CITY OF ALBUQUERQUE

**RE: Santa Monica Estates
Release of Financial Guarantee
Grading Plan Certification Engineer's Stamp Date 1/20/2017
Hydrology File: D18D054E**

**RE: Santa Monica Estates
Release of Financial Guarantee
Grading Plan Certification Engineer's Stamp Date 1/20/2017
Hydrology File: D18D054E**

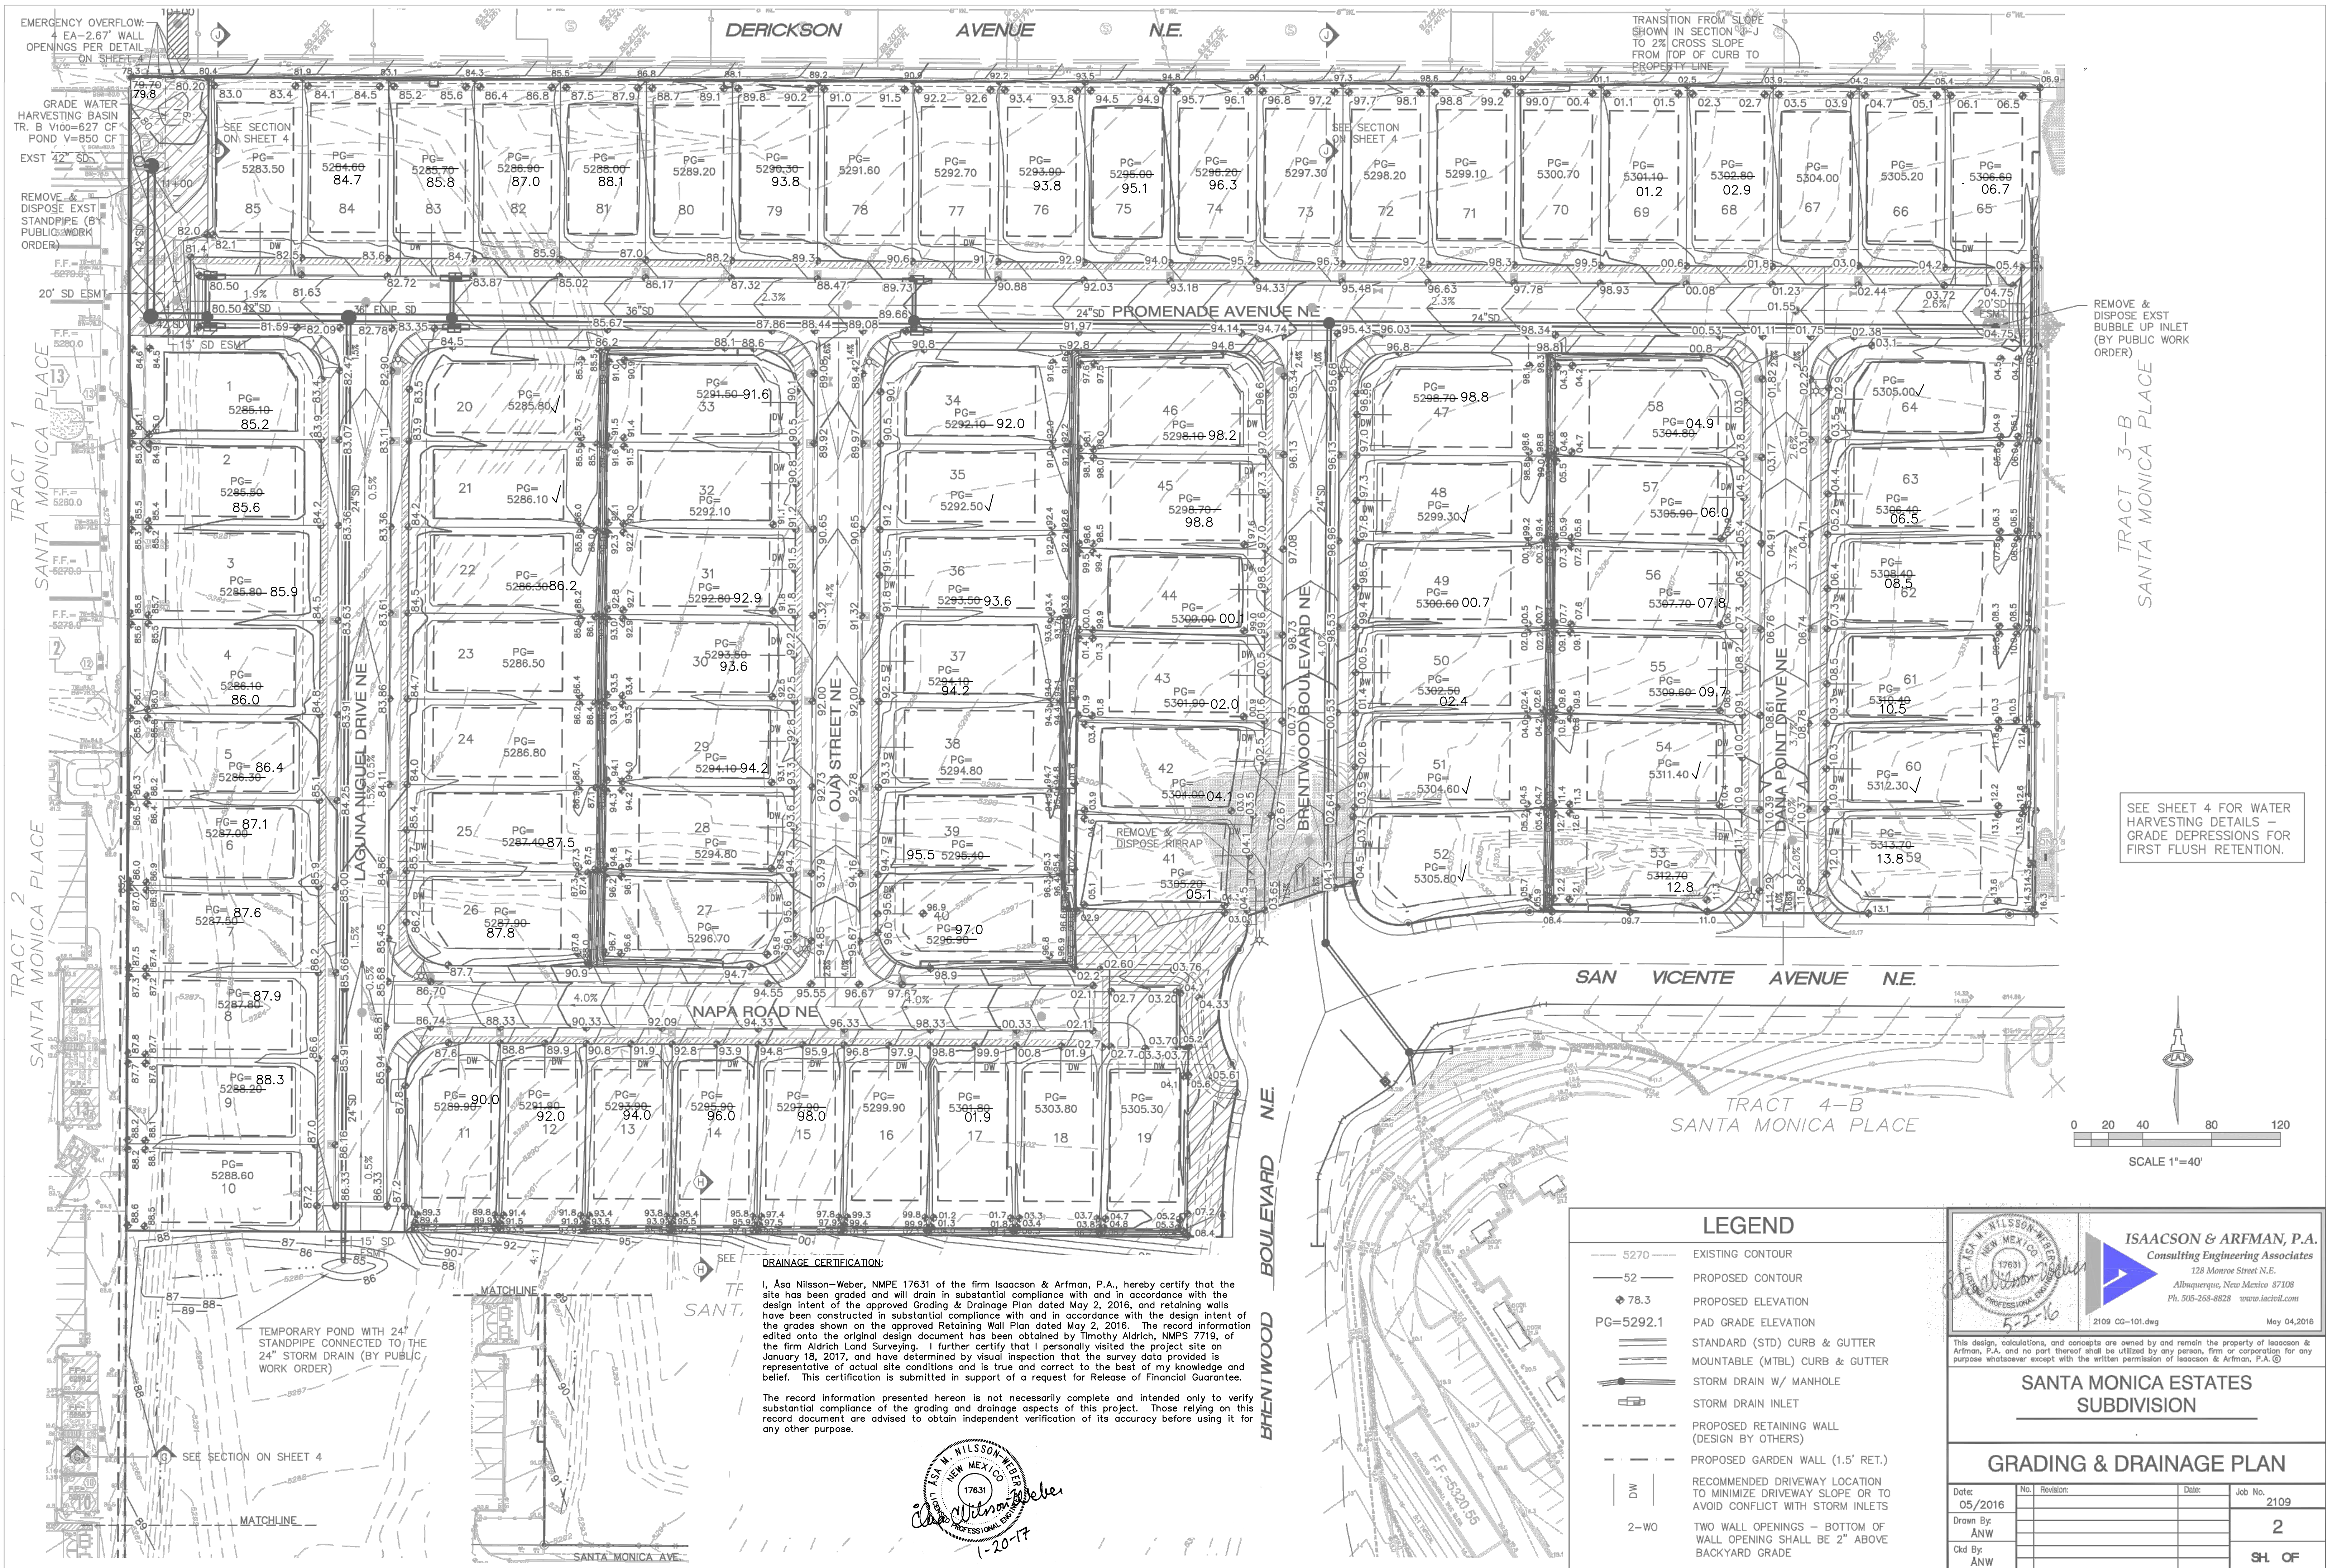
1. The retaining wall in the southeast corner of Lot 59 is incomplete.
2. The east terminus of Promenade Avenue, adjacent to Lots 65 and 66 needs to be swept and cleaned.
3. The pond and standpipe at the southern terminus of Laguna Niguel Drive is silted-in and no longer functioning as intended. Several measures need to be taken:
 - a. The pond bottom needs to be excavated to leave 18" of the standpipe exposed. If the standpipe cannot be exposed 18", please provide an alternative that will restore system function.
 - b. Restore the 4:1 side slopes.
 - c. Erosion protection is needed to slow erosion around the edge of the pond, especially on the eastern side.

Based upon the information provided in the submittal received on 1/23/2017 and corrective actions provided via email on 2/10/17, the above-referenced plan is approved for Grading and Drainage Certification for Release of Financial Guaranty.

See attached photos showing that your comments have been addressed. If all looks OK, please email me the approval letter so we can deliver it to Muhanned.
